30 October 2010

Re: Application for Planning on Broadwater site, Welwyn Garden City

02. BRIDGE LEVEL PLAN : PROPOSED

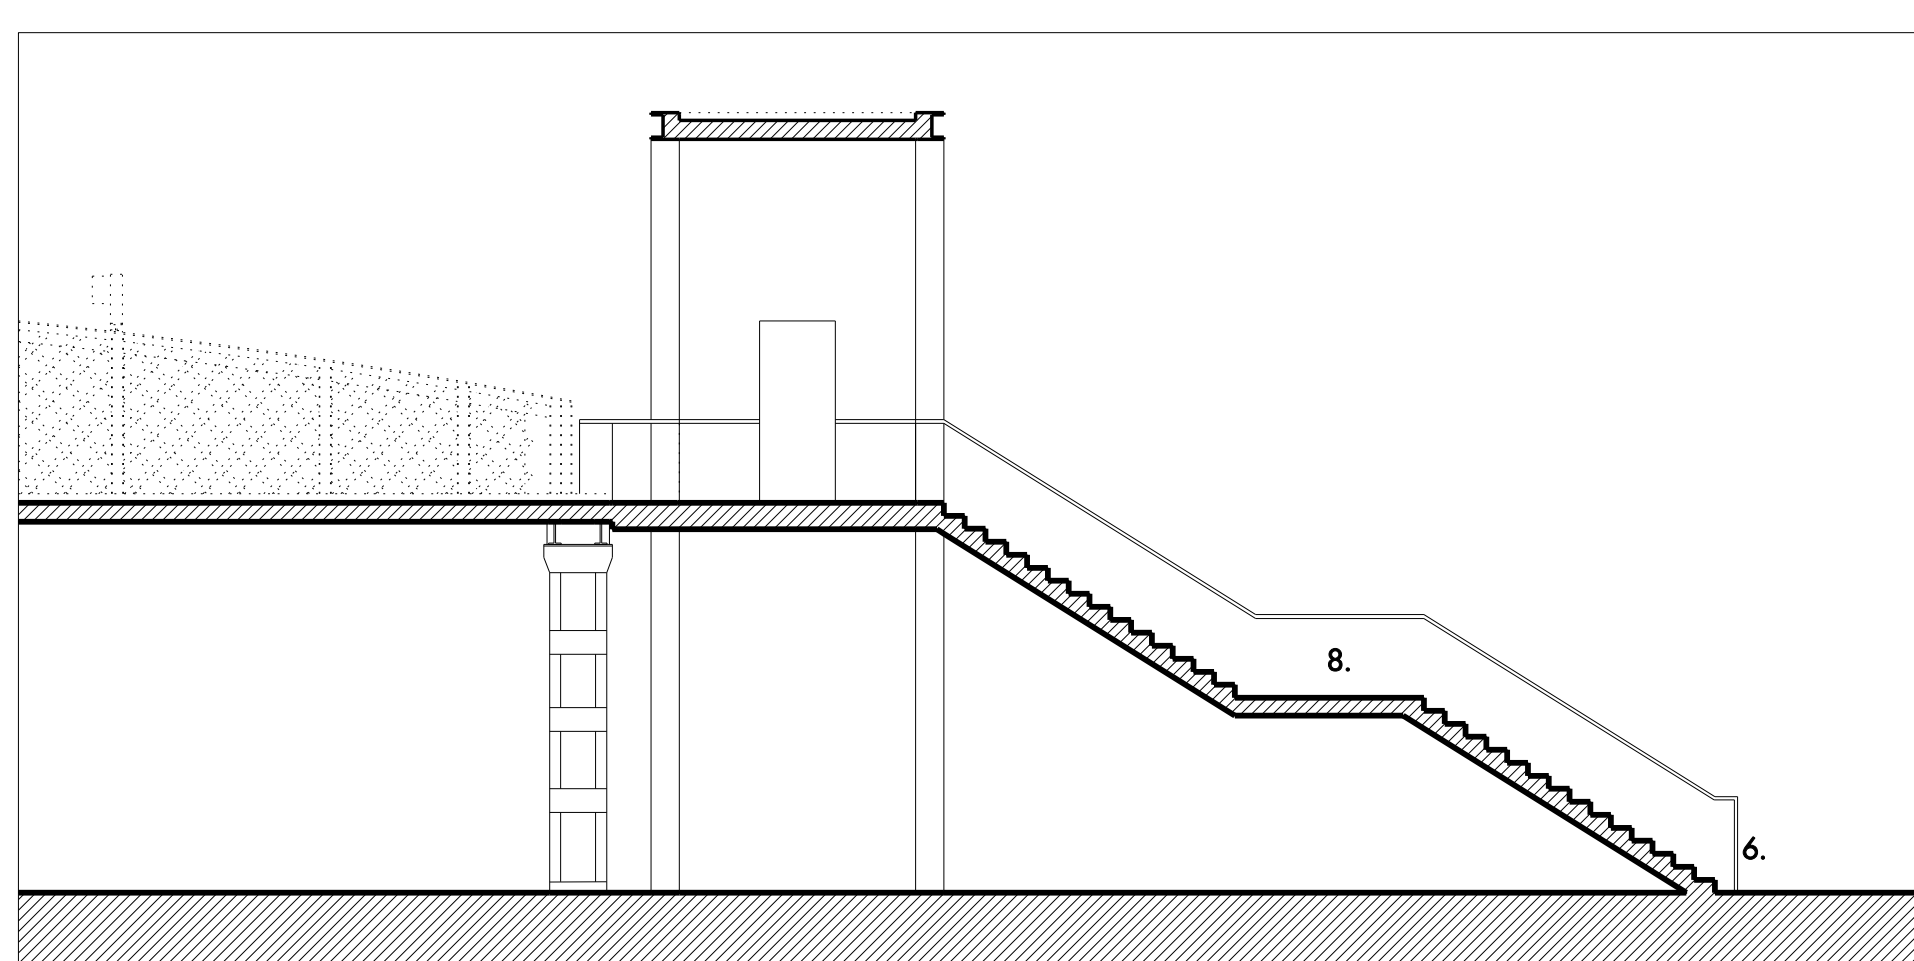
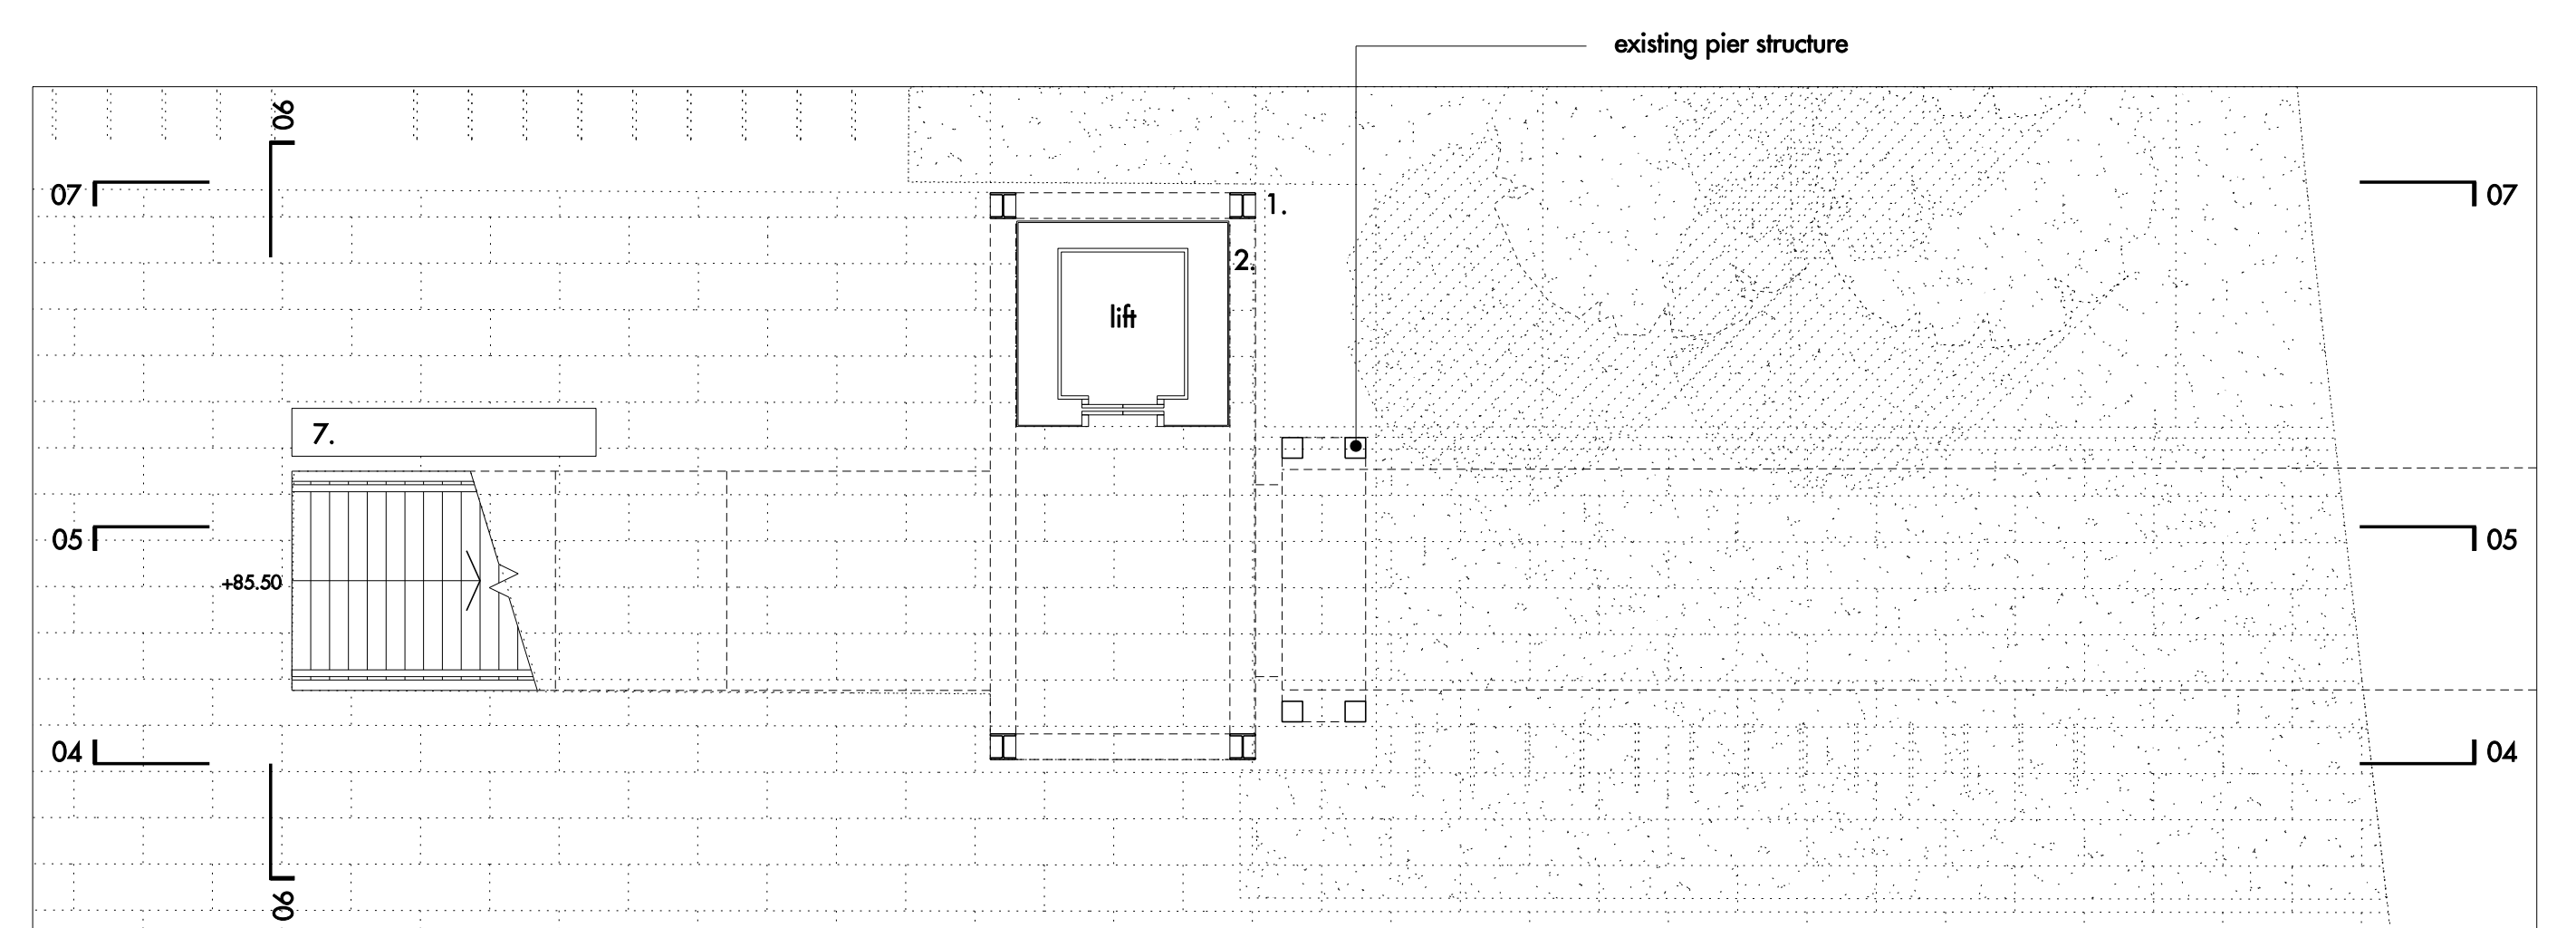
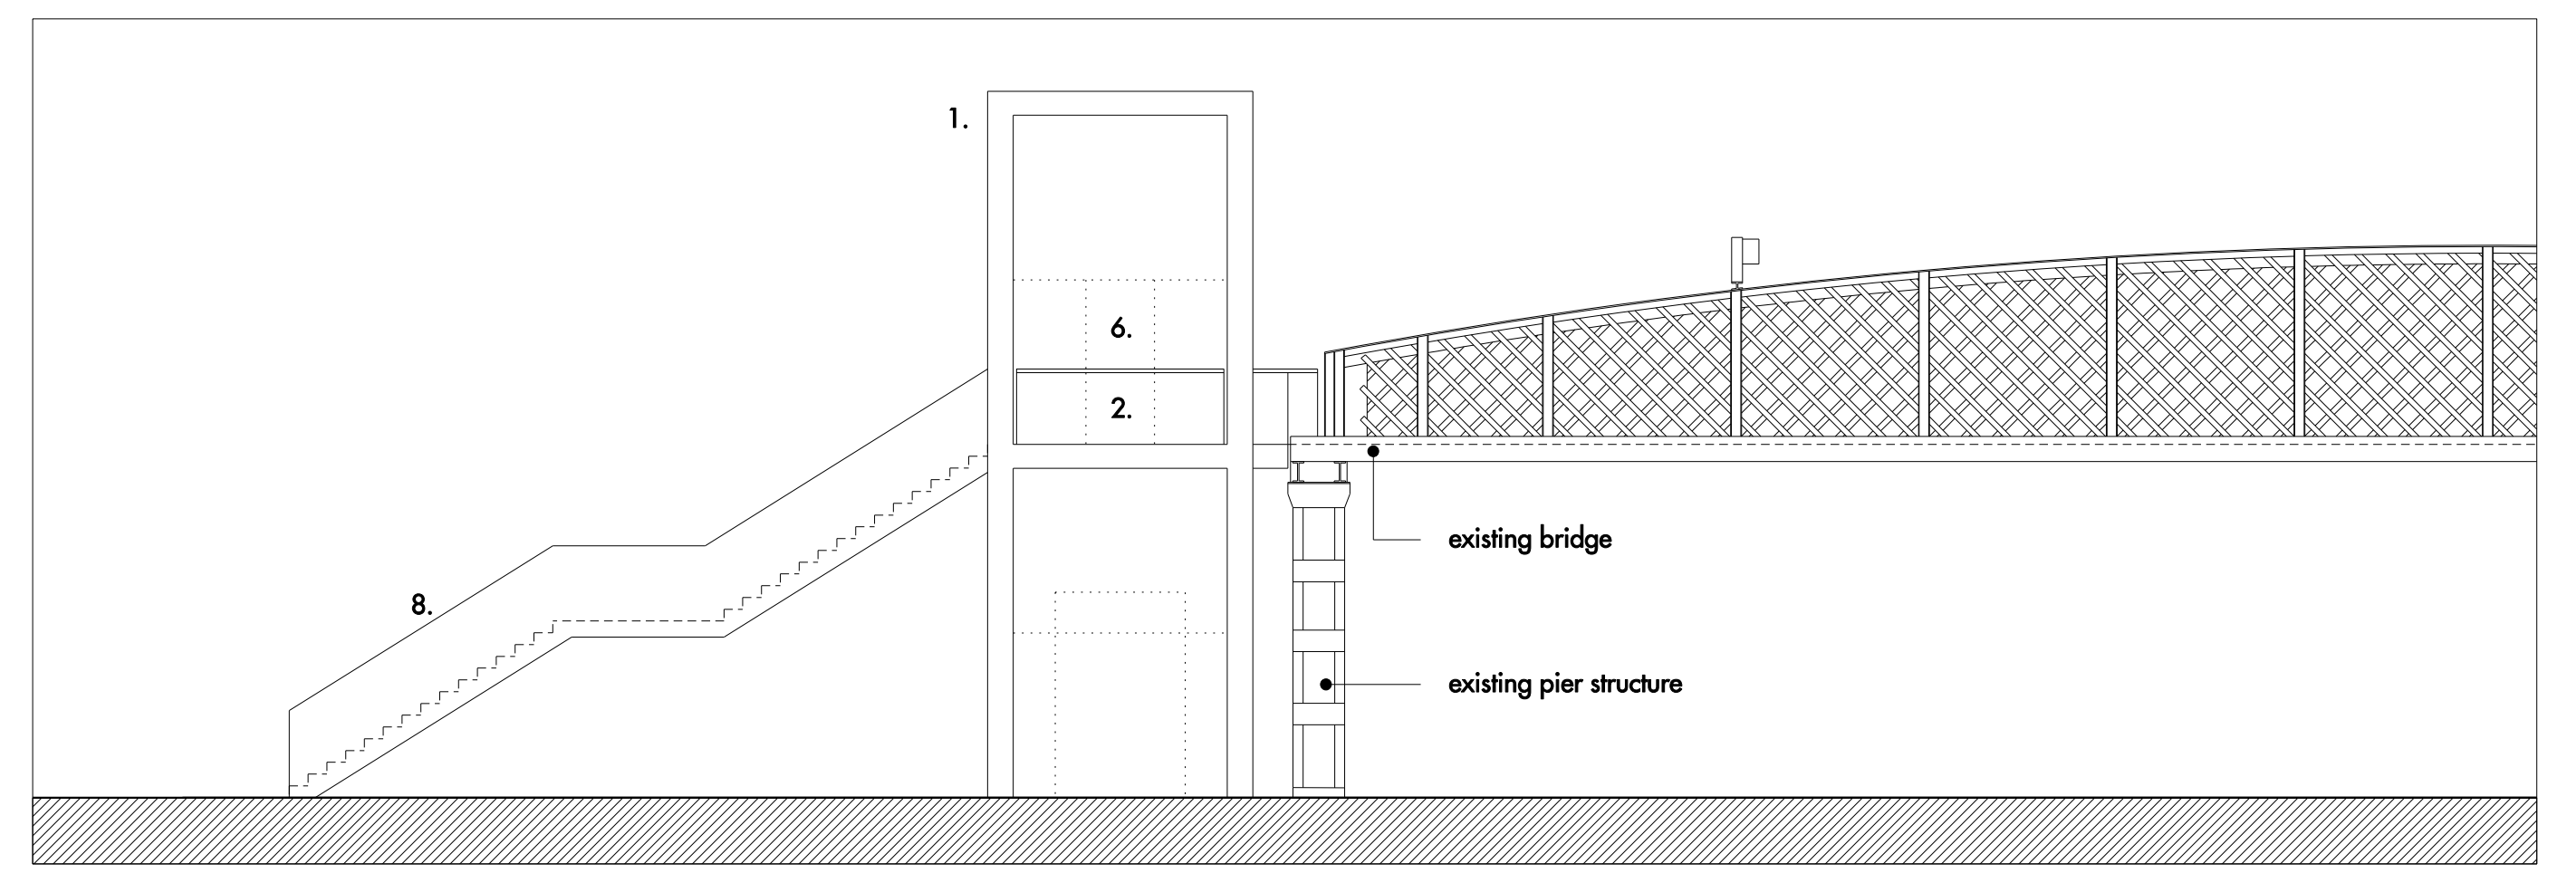
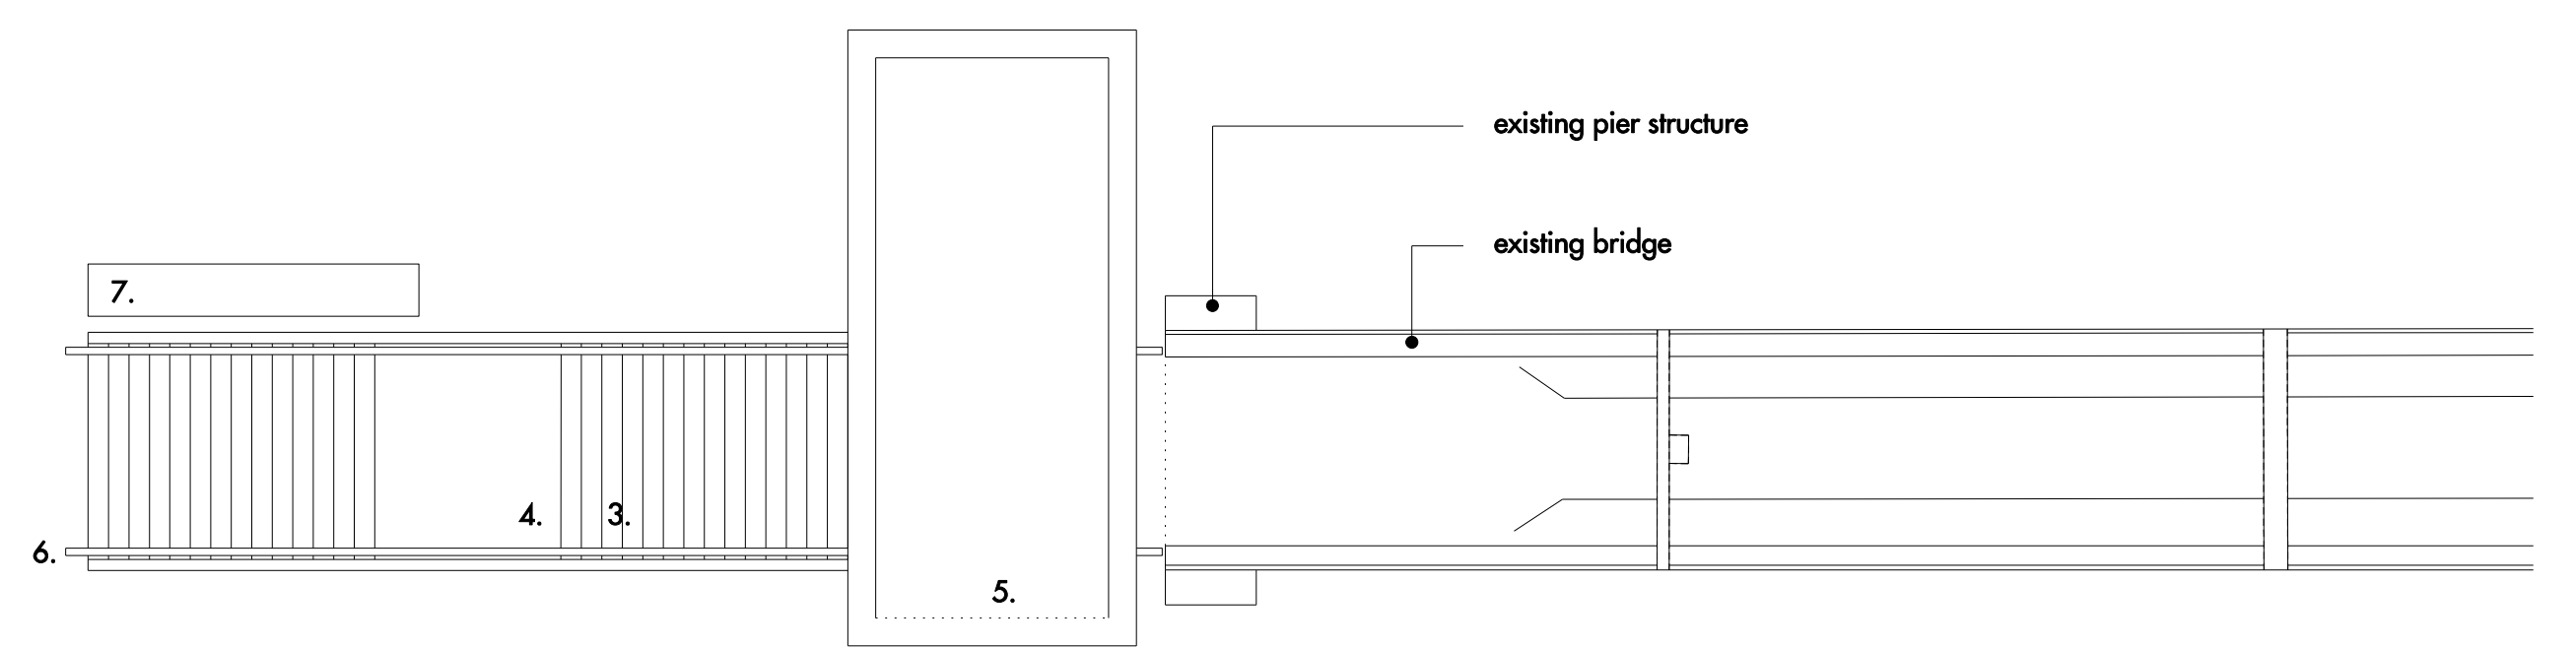
The footbridge over the railway shown in the plan seems to stop and end in a lift, which would be most unsuitable and could be highly dangerous with the increased numbers of people that would use it. A new and more substantial bridge is needed and it would be preferable to have escalators as well as a lift at the eastern end.
